COUNTY COUNCIL'S RESPONSE TO CONSULTATION ON THE FOLLOWING DEVELOPMENT PROPOSAL

Application No: 18/01894/OUT

Proposal: Outline planning permission with all matters reserved for up to 25 dwellings with associated open space, parking and sustainable drainage.

Location: OS Parcel 4300 North Of Shortlands And South Of High Rock, Hook Norton Road, Sibford Ferris.

Client	LAND & PARTNERS LTD	Scale	1:1250	Size	A3	Drawn	AB	Designed	-
Project	SIBFORD FERRIS	Drawing Status	FOR INFORMATION		Date	JULY 18		Rev.	-
Drawing title	ROAD DESIGN & SWEEP PATH ANALYSIS FOR A 10.2m REFUSE VEHICLE		Drawing No.	SK02		Rev.	-

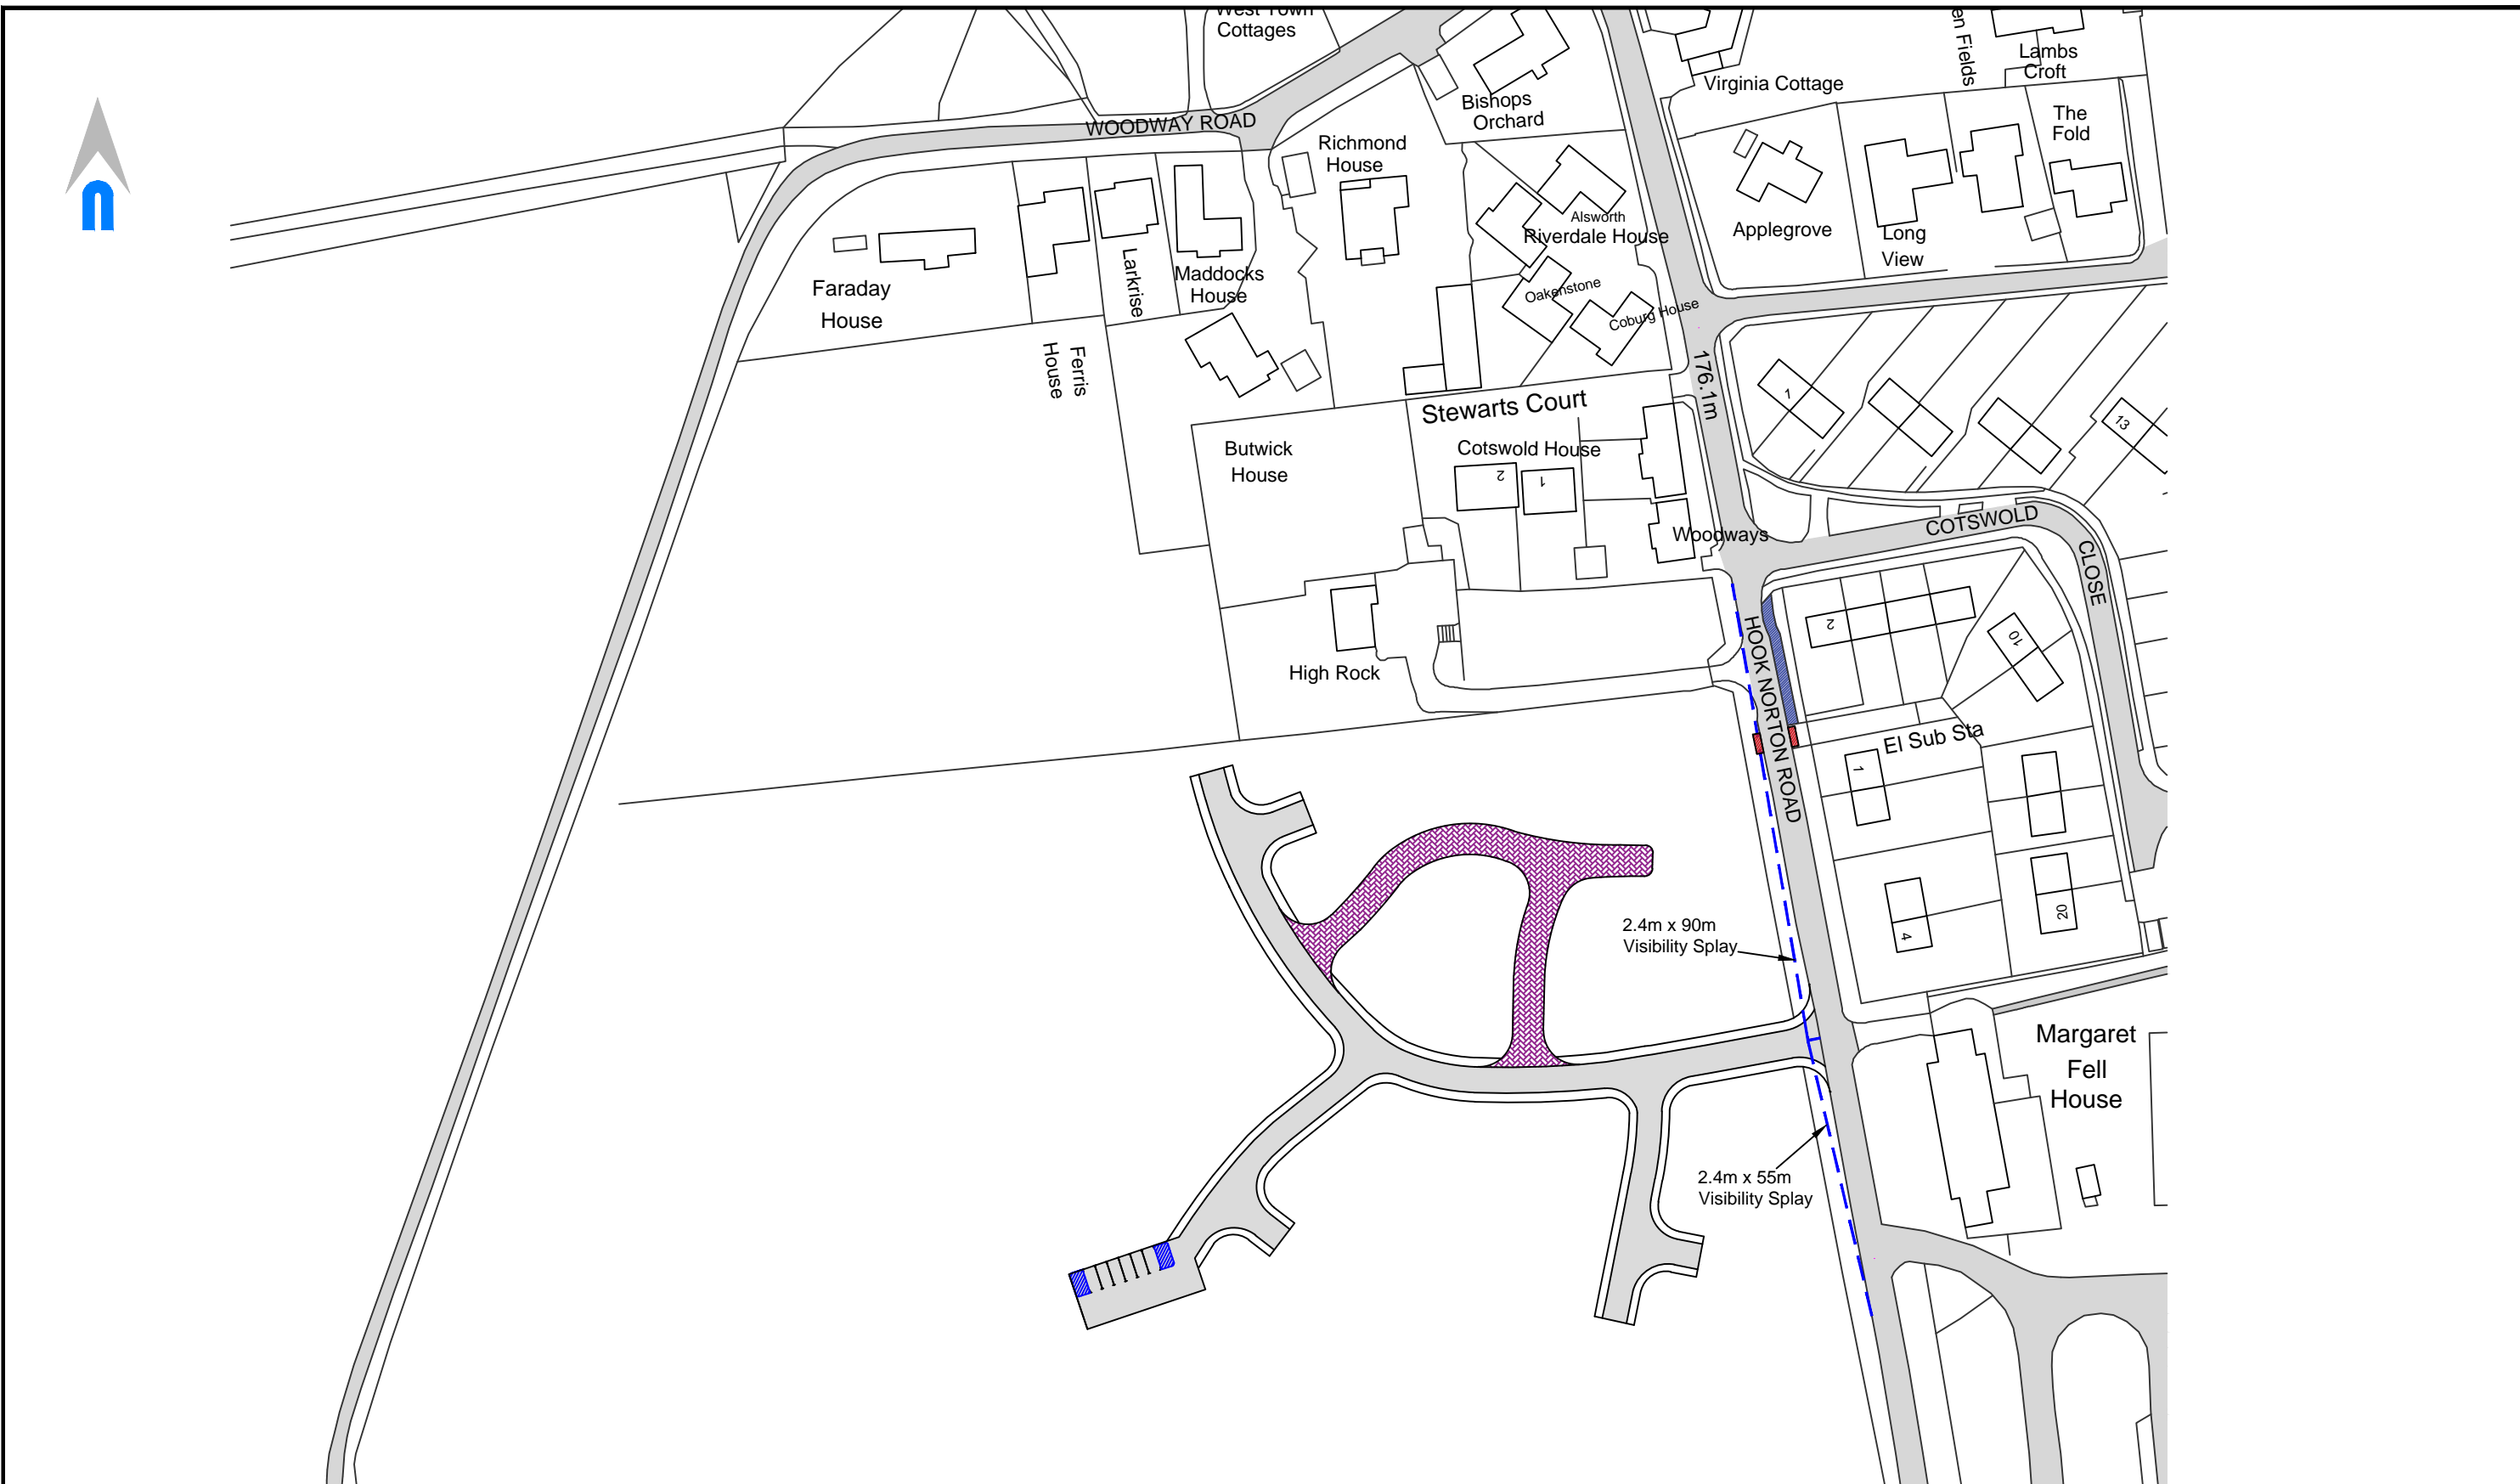
The site roads must be able to accommodate an 11.6m long refuse collection vehicle, as advised at the pre-app stage. It appears to be tight even for a 10.2m vehicle as shown in Appendix G.

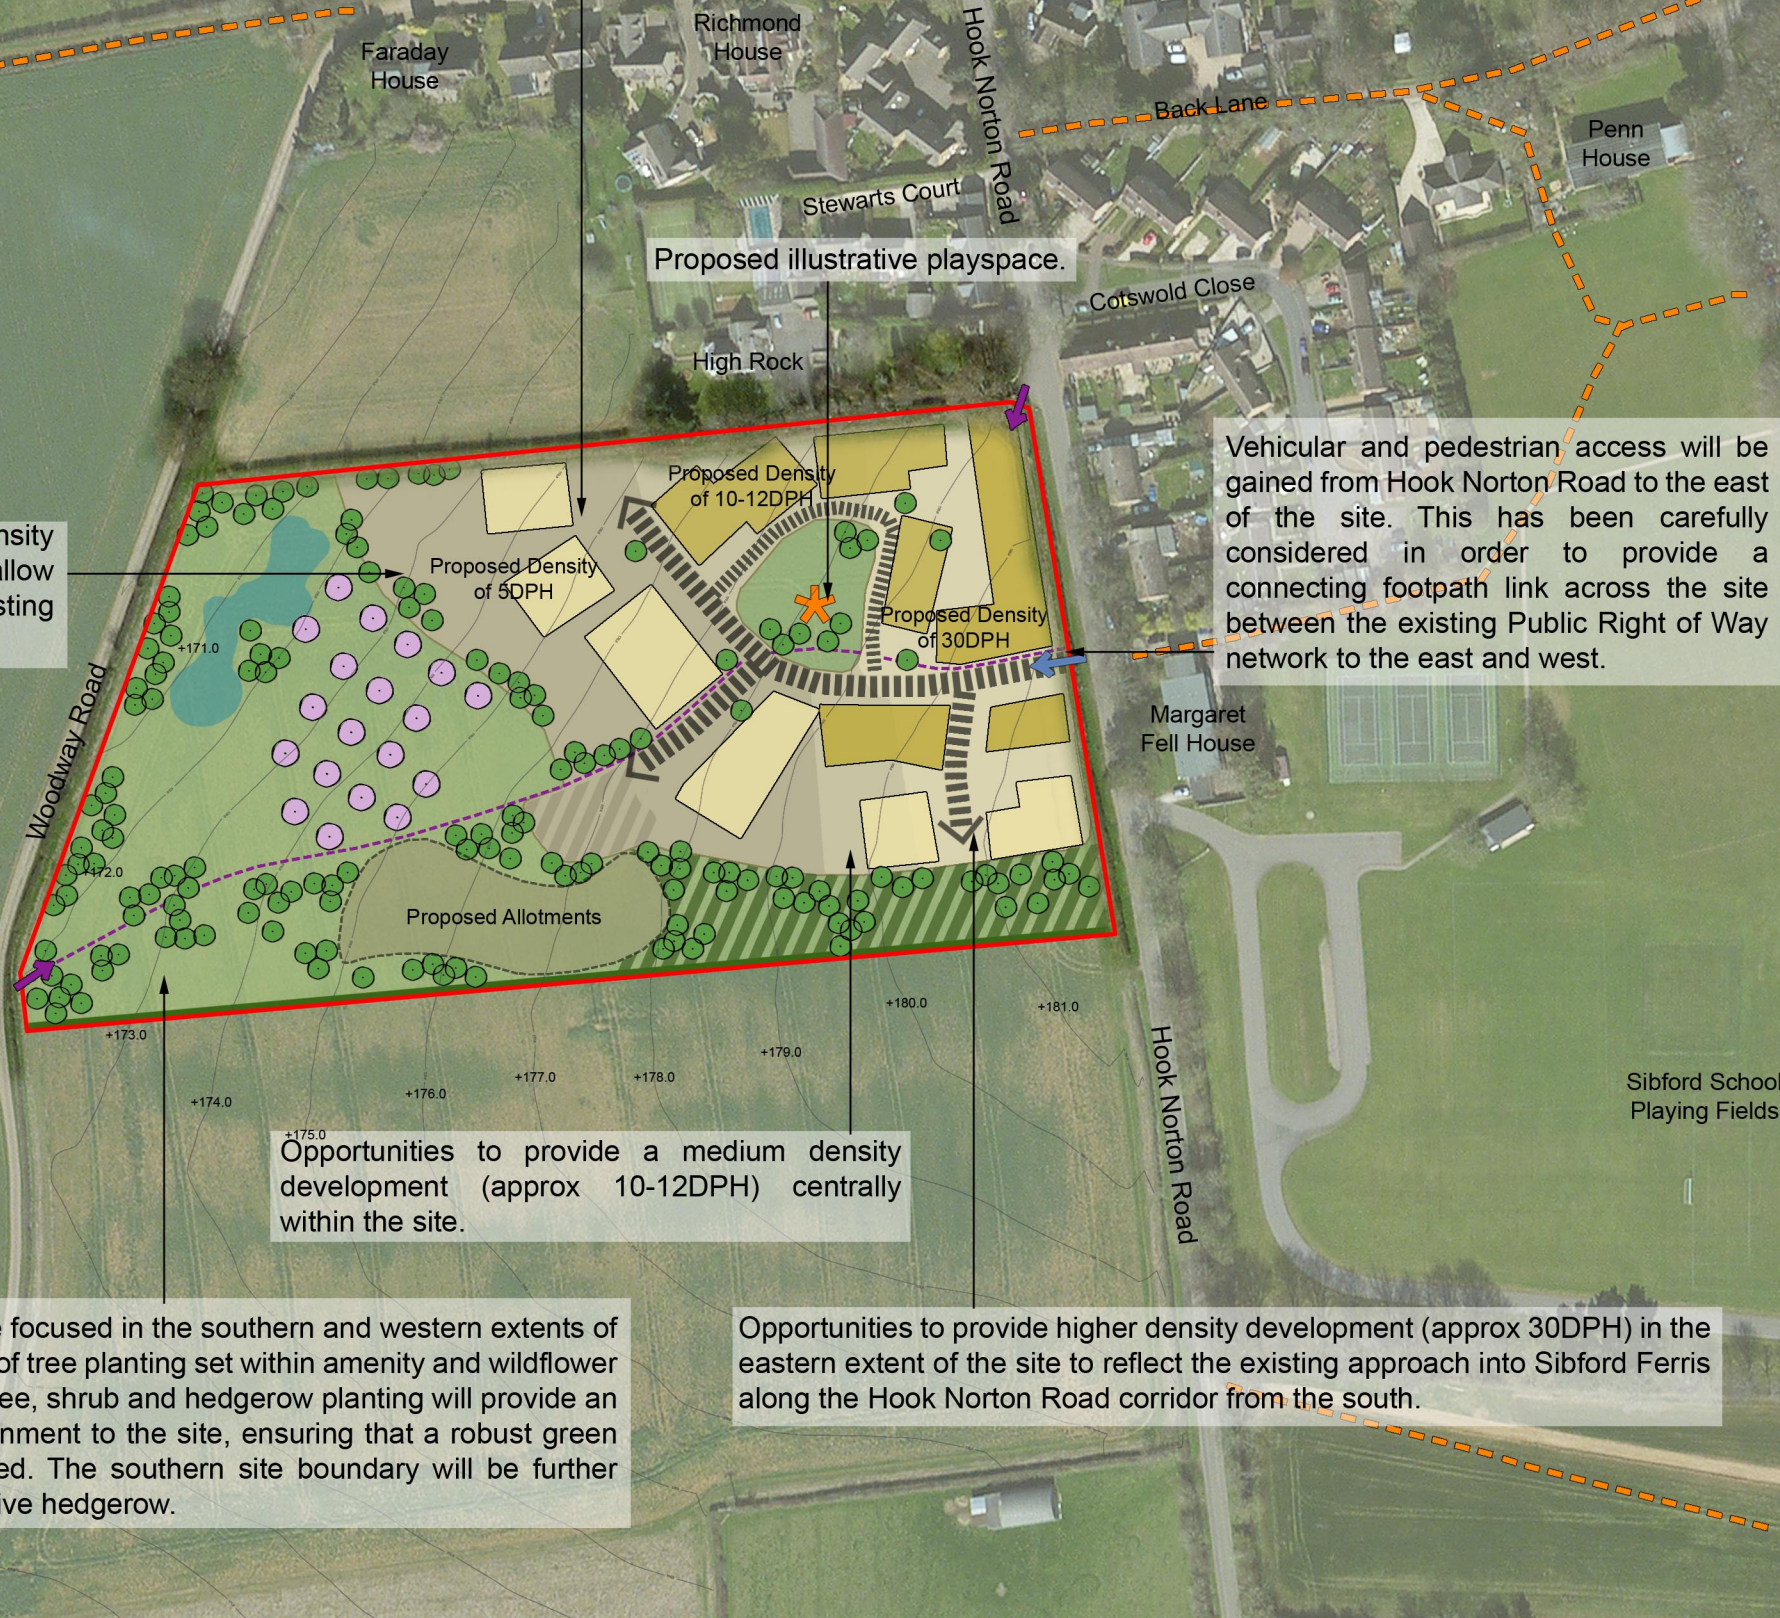
A preliminary concept schematic is provided by the applicant which indicates an internal footpath network on the site. A footpath is proposed to run parallel to Hook Norton Road within the site. The footpath is proposed on the western side.

The S278 works will include a footway connection to tie-in with the existing facilities. However, the pedestrian access point is shown in two different places on the two drawings – drawing SK04 (Appendix H) shows it opposite the electrical sub-station, whilst the Concept Schematic (Appendix F) shows it right in the NE corner of the site. Either way, the footway should connect to the east side of Hook Norton Road, south of Cotswold Close. Dropped kerbs and tactile paving will need to be included across the Cotswold Close bellmouth.
